CAVERSFIELD PARISH COUNCIL

17 June 2021

Caversfield Parish Council has considered Bicester Motion's planning application reference 21/01224/OUT for Land at former RAF Bicester, OX26 5HA with the proposal "Outline planning application for Automotive Experience Quarter comprising Commercial, Business and Services uses (Class E), Light Industrial (Class B2), Local Community and Learning Uses (Class F) and vehicle circuits (Sui Generis) with all matters reserved aside from that of access".

Figure 45. Proposed Automotive Demonstration And Driver Experience Diagram (not to scale)

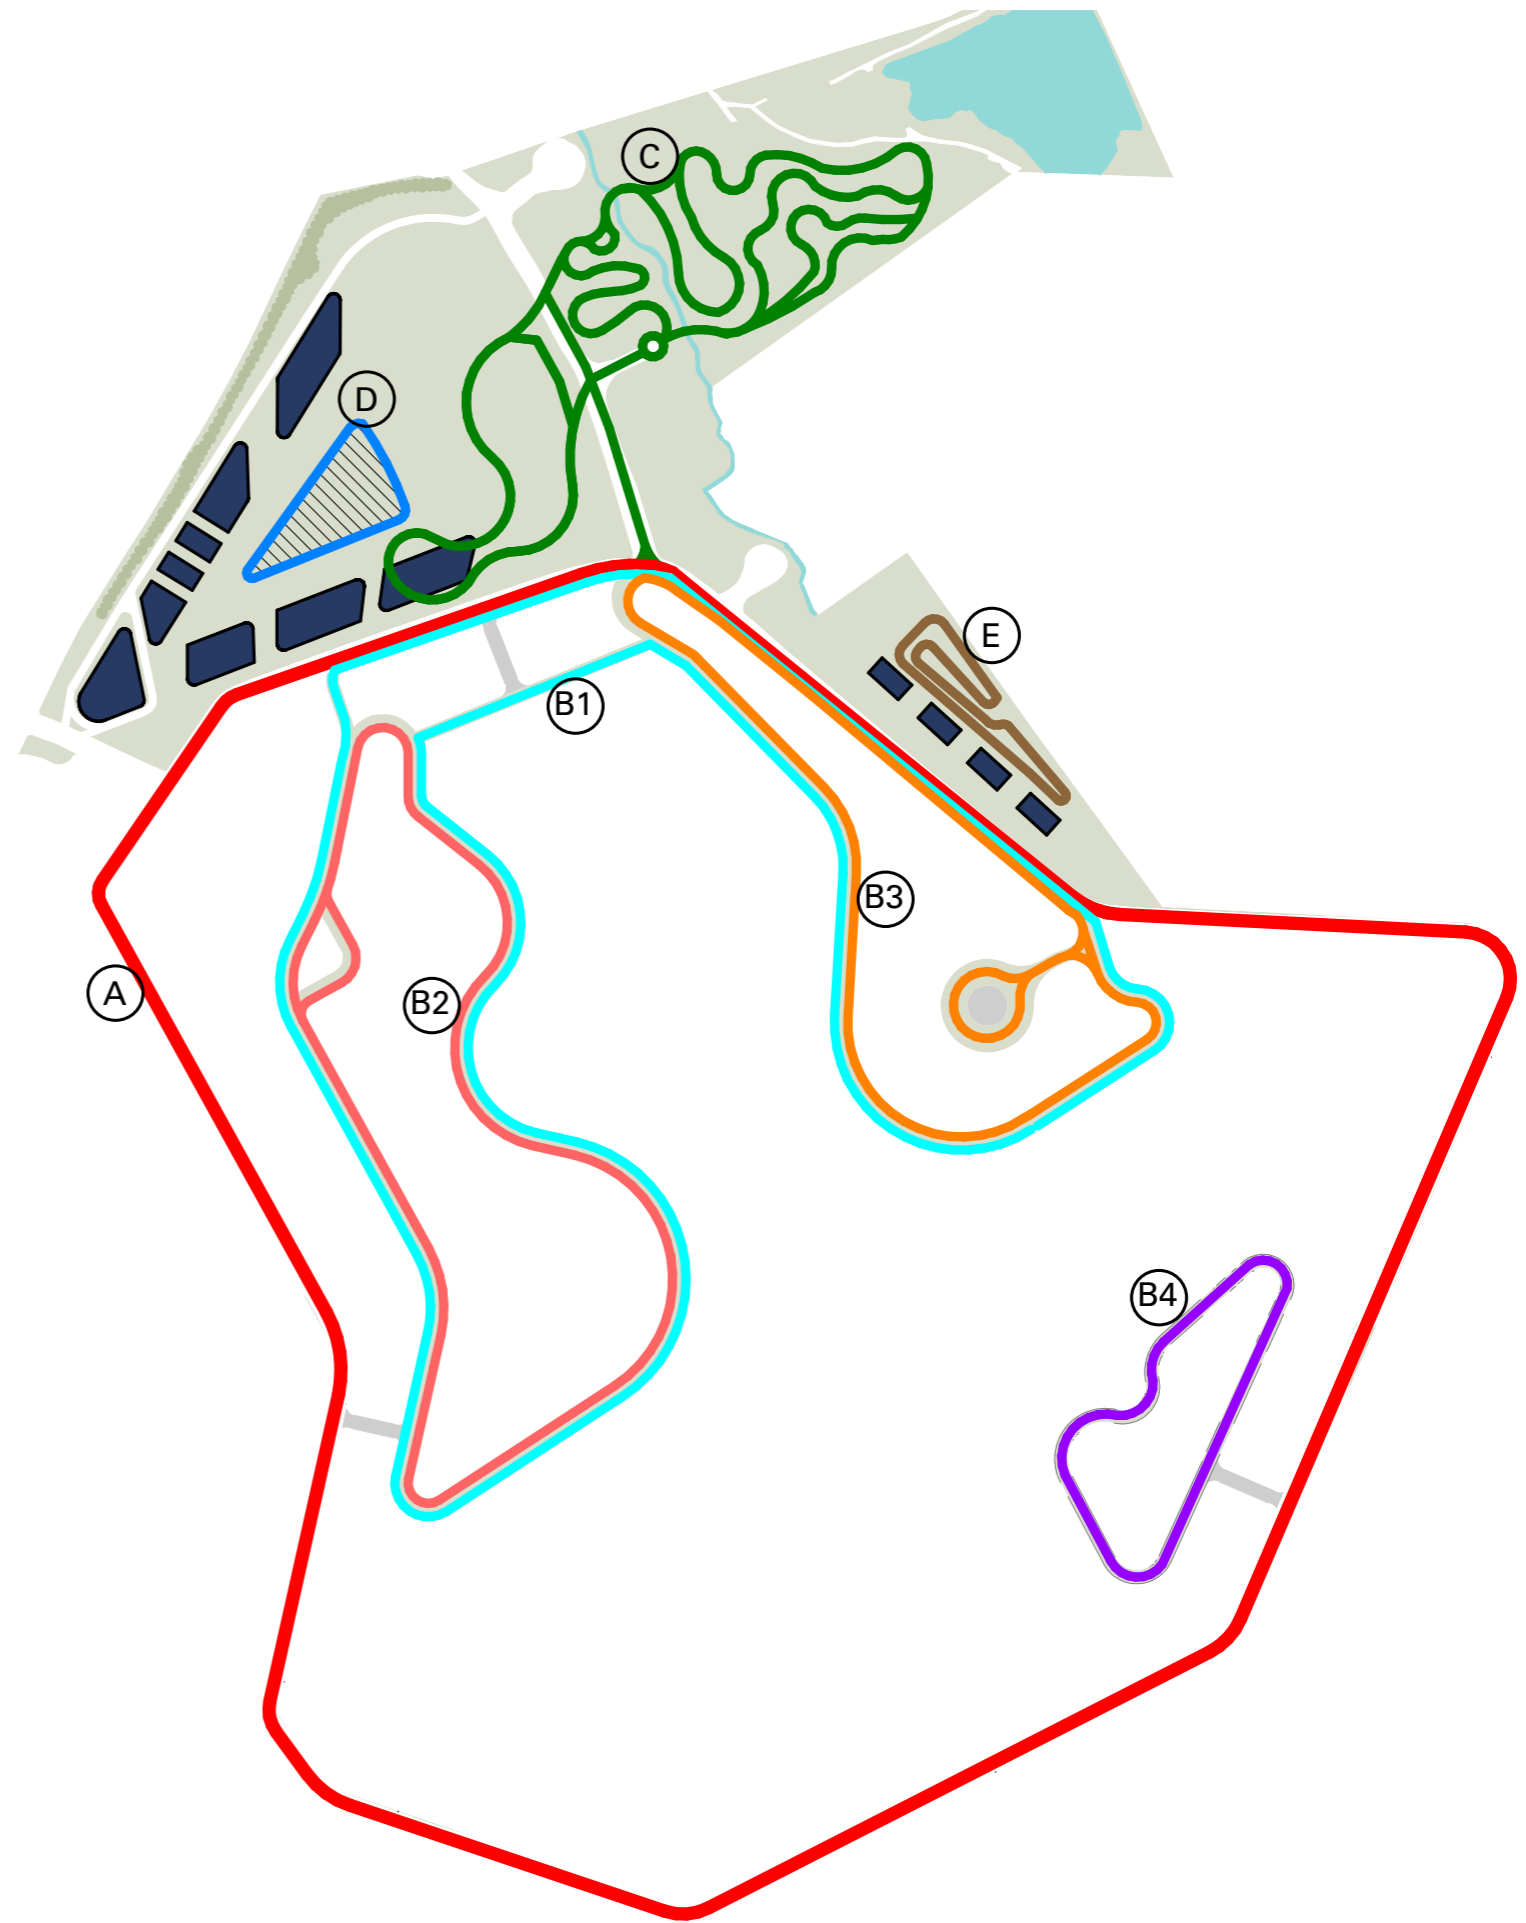
The views across the historic flying field, from many angles (including from above), will be hugely harmed by the imposition of the proposed motor circuit tracks into the flying field.

The Parish Council is concerned about the noise impact from this three-circuit proposal. The current experience of 'small' events and regular vehicle testing around the present circuit has already had an impact on the villagers living closest to the airfield (particularly on Turnpike Road, Manzel Road and the residents at the eastern end of Thompson Drive). With the current requirement for many staff to work from home and the future likelihood of this continuing to some extent, it is known that some villagers have felt they had to move because the noise level was already too intrusive (for instance there have been days when it has been impossible for villagers to hold virtual meetings because of the current volumes).

job title: Bicester Motion  
 Brand Experience Application  
 drawing title: Proposed Access

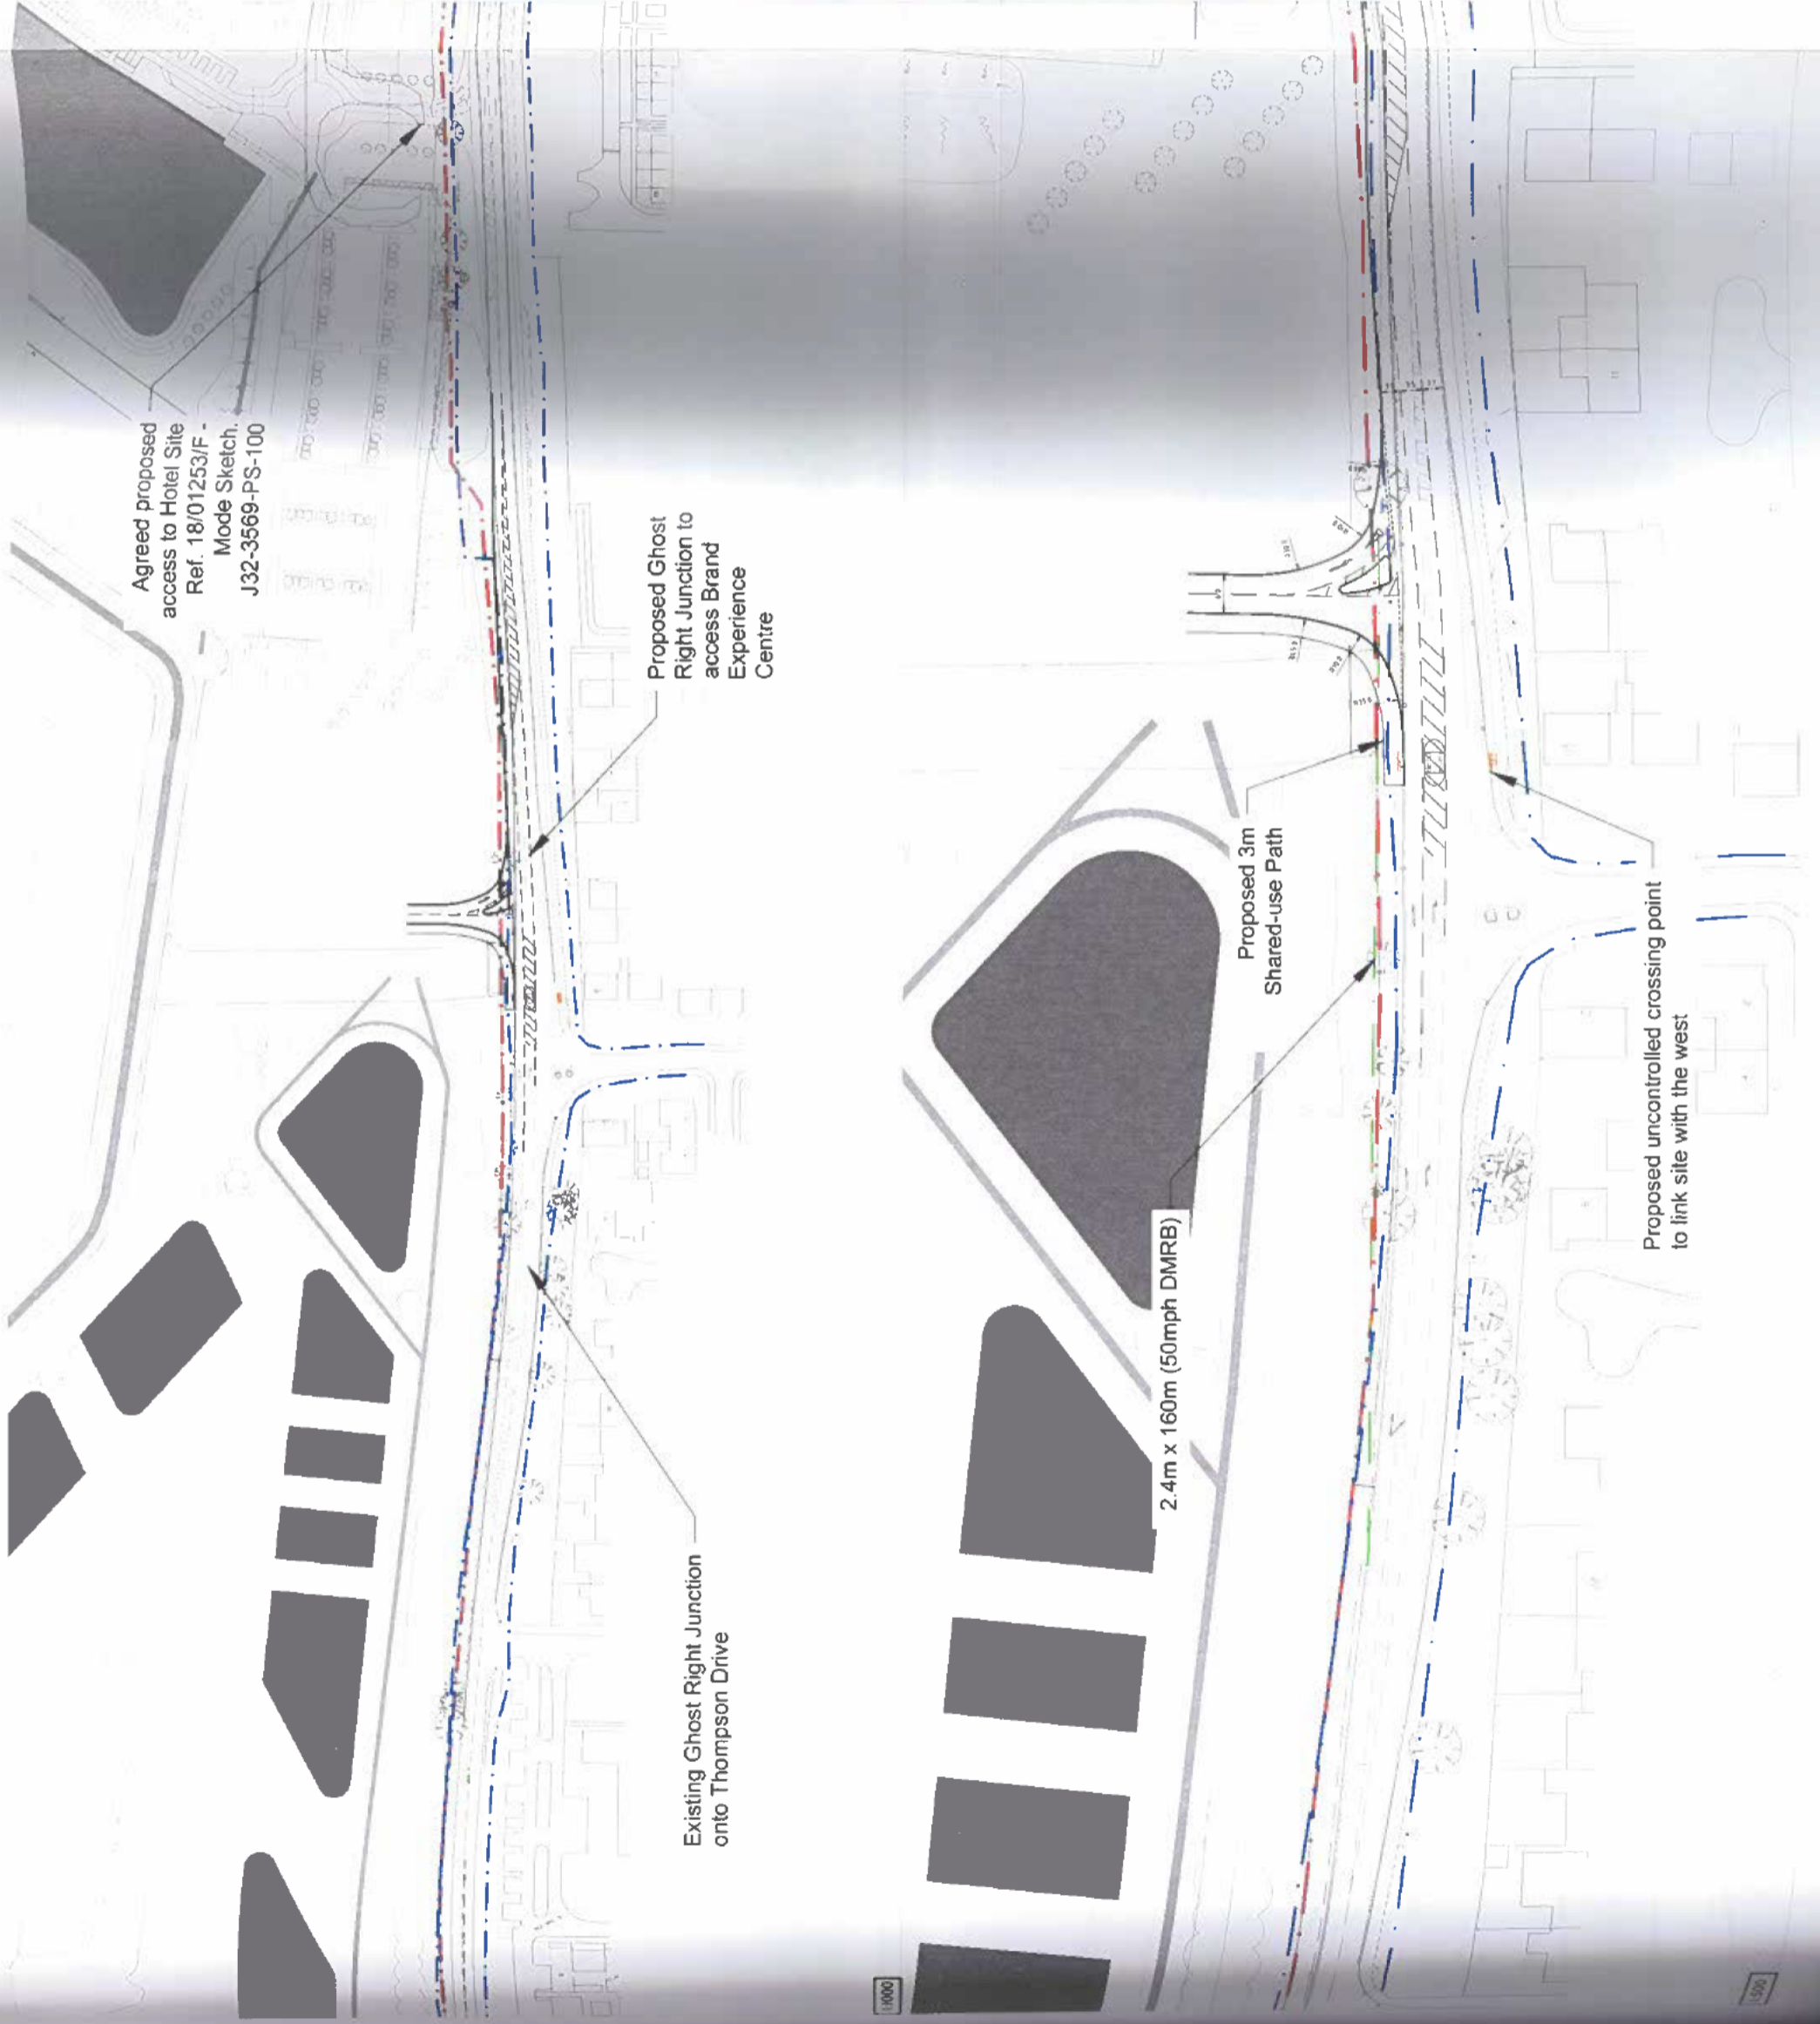
The proposed uncontrolled right filter on the Buckingham Road (A4421) to access the site from the south has caused concerns about safety; furthermore, it does not appear to make any mitigation on the impact of the residents of Thompson Drive attempting to leave that road. The Parish Council believes that there should be a permanent traffic management proposal, including traffic lights and pedestrian access, for this entrance.
